CITY OF PORTLAND

Permit Number: 080472

This is to certify that COLLINS JAMES T & CAROLYN L COLLINS ITS/Michael M Grahas permission to Demo existing 18'x24' garage. Build new 30'x24' garage in existing locationAT 128 MADELINE ST PORTLAND, OR 97201 179 E003001

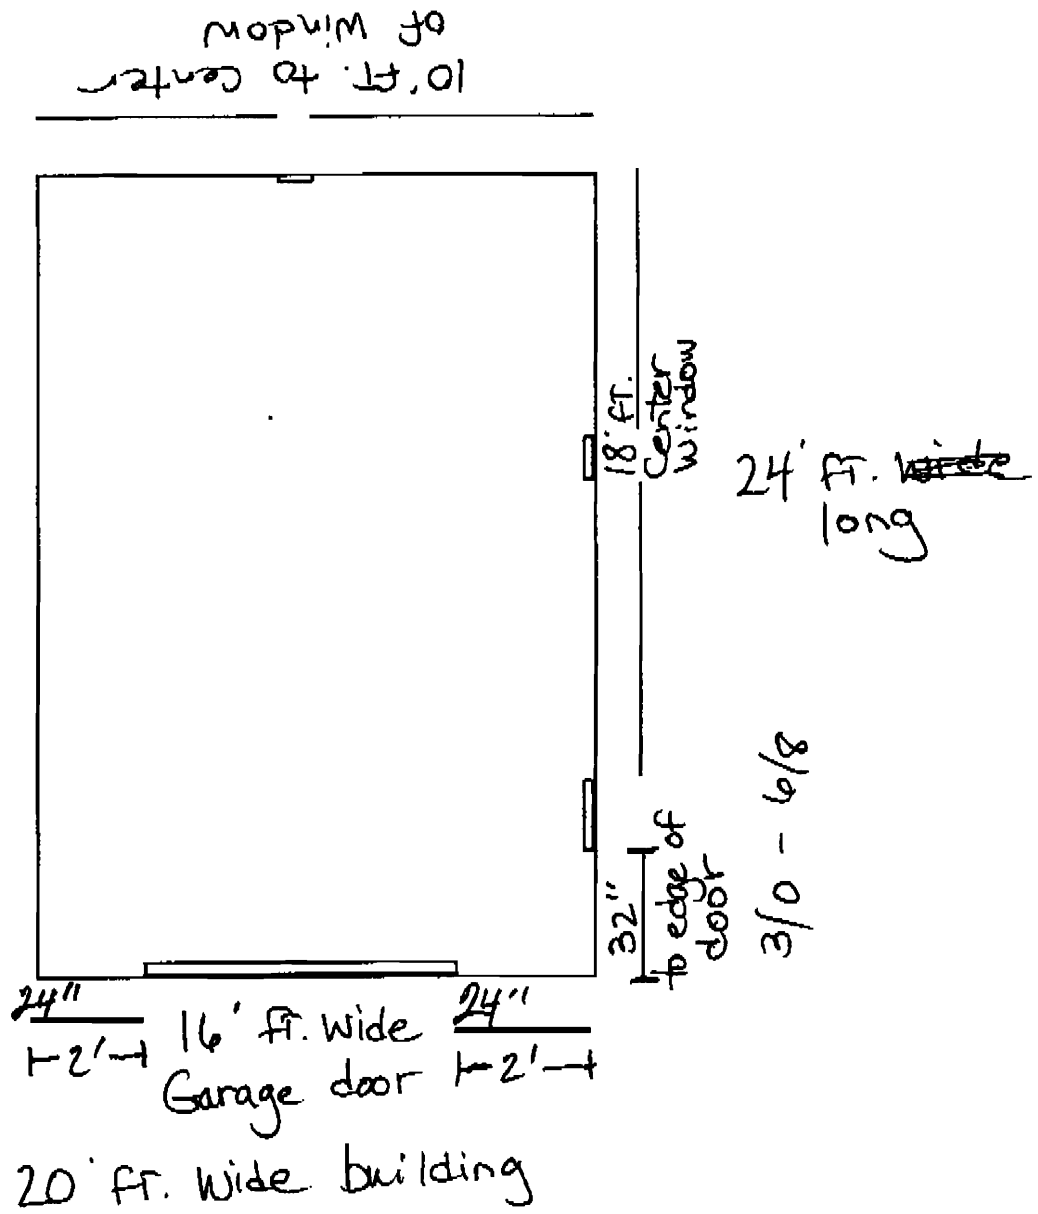
5/19/2008-tm: spoke to owner and contractor that plans are insufficient and we need framing details before we can issue the permit.
